From: Roopa Bilichodmath [REDACTED]
Sent: 01 February 2022 15:15
To: Anita Gardner <Anita.Gardner@arun.gov.uk>
Subject: LU/338/21/PL - Land on south side of Eldon Way Littlehampton BN17 7HE

STAGE 1 ROAD SAFETY AUDIT DESIGNER'S RESPONSE

Auditor: Paul Martin – Road Safety Answers
Audit Reference: RSA503
Date Response Completed: 15/12/2021
Scheme: Access to new Keystone Centre, Eldon Way, Littlehampton

Access Overview and Visibility Splays

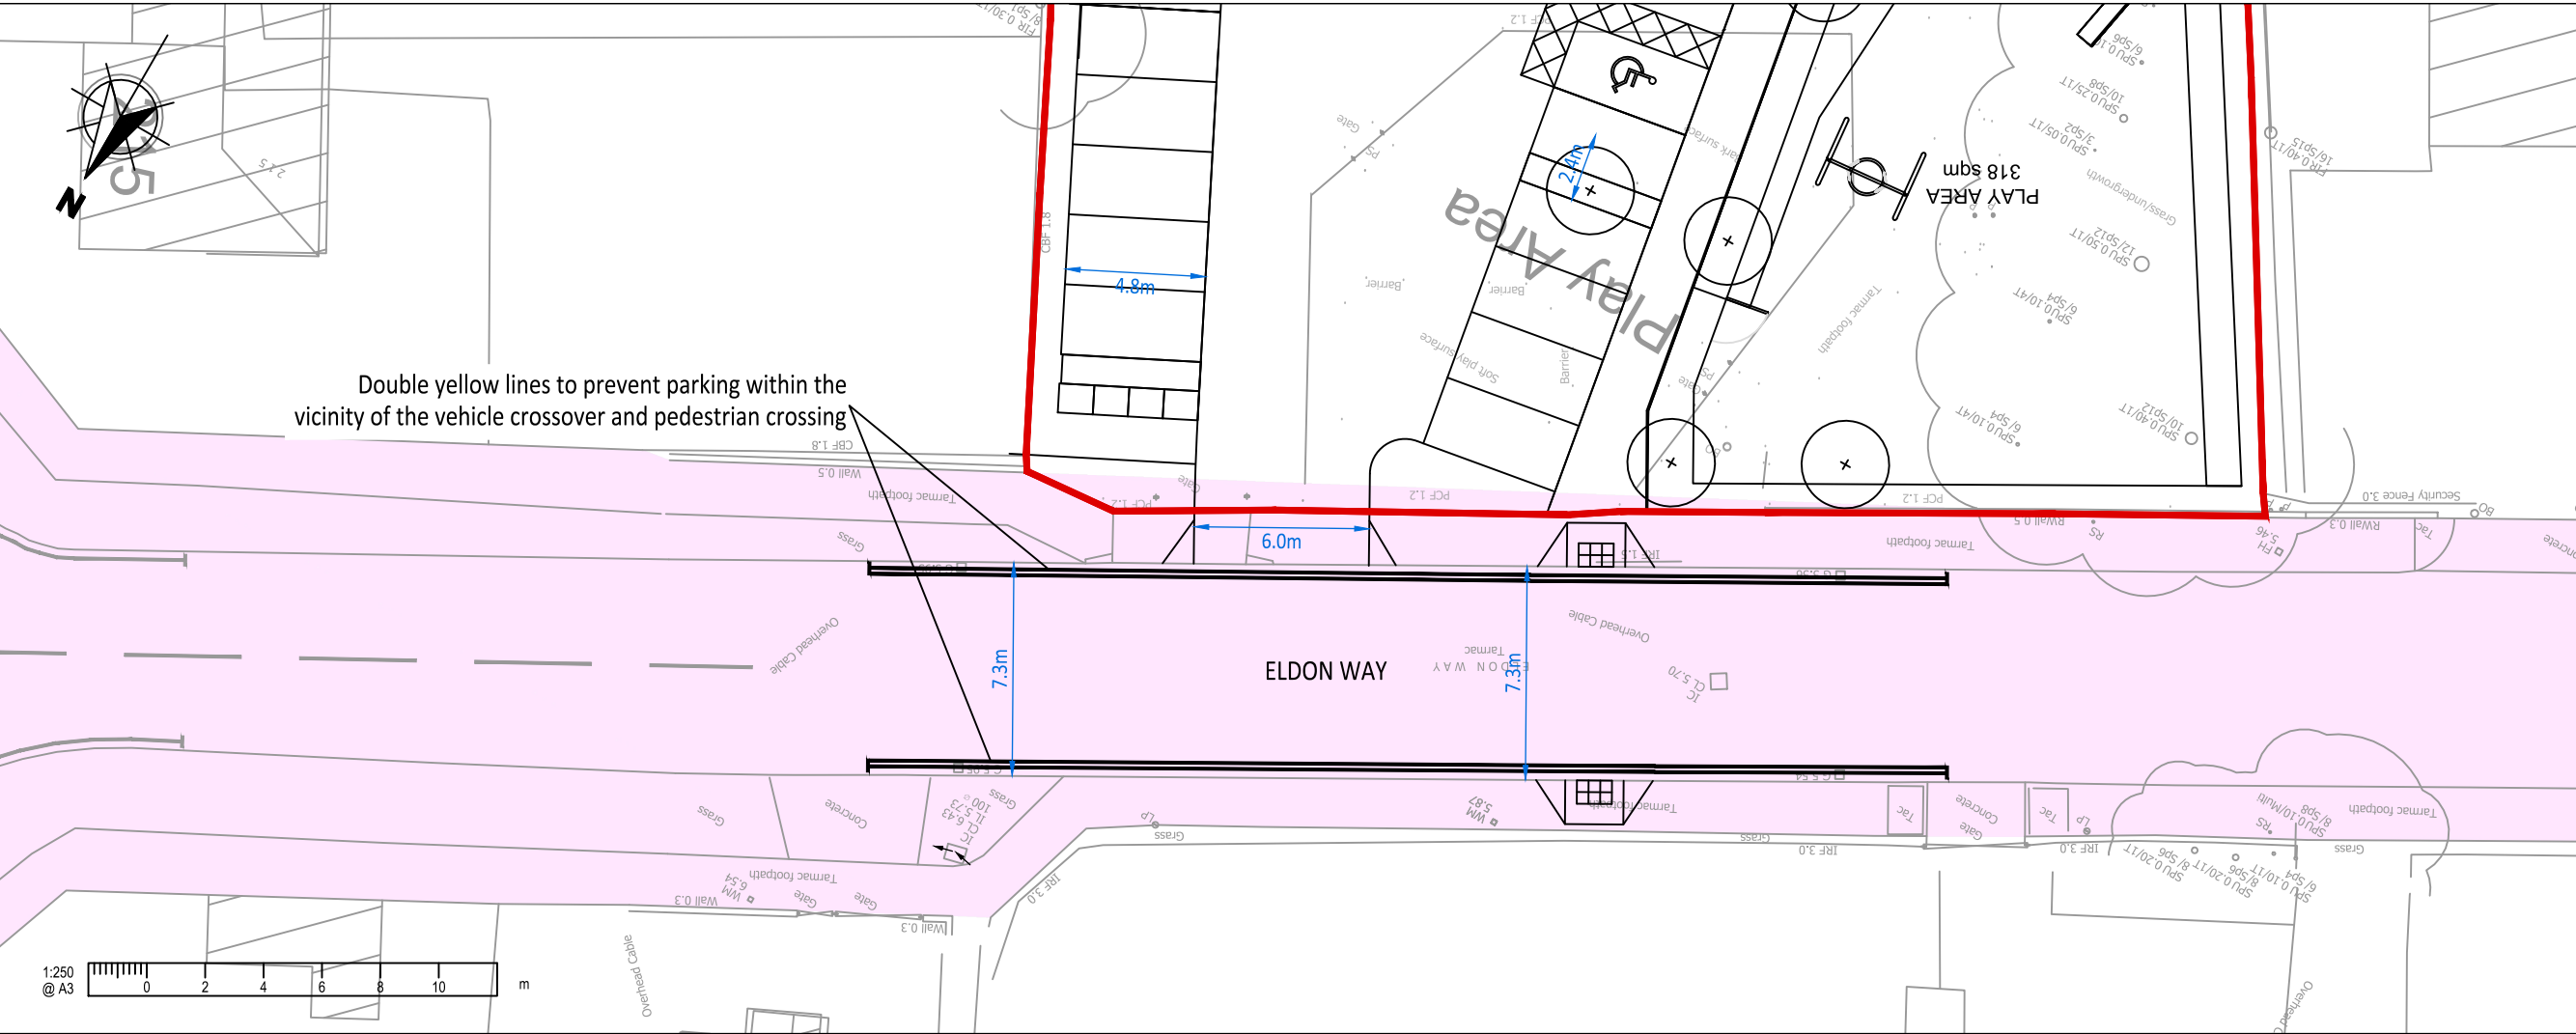
2.1	Yes	Yes	Recommendation enhanced to double yellow lines to ensure that no parking takes place in the vicinity of the proposed vehicle crossover and pedestrian crossing facilities. The existing single yellow line TRO is active between the hours of 8am – 6pm Mon – Sat, this would not necessarily coincide with proposed operating hours.	The LHA are satisfied that the now proposed TRO for parking / loading restrictions along the site frontage on Eldon Way will ensure no parking / loading takes place in the vicinity of the proposed vehicle crossover and pedestrian crossing facilities. TRO to be secured under an s106 agreement for planning.	Agreed, a TRO plan (Drawing 2021-6313-001 Rev D (December 2021)) has been produced and demonstrates the proposed indicative alignment of the road markings.
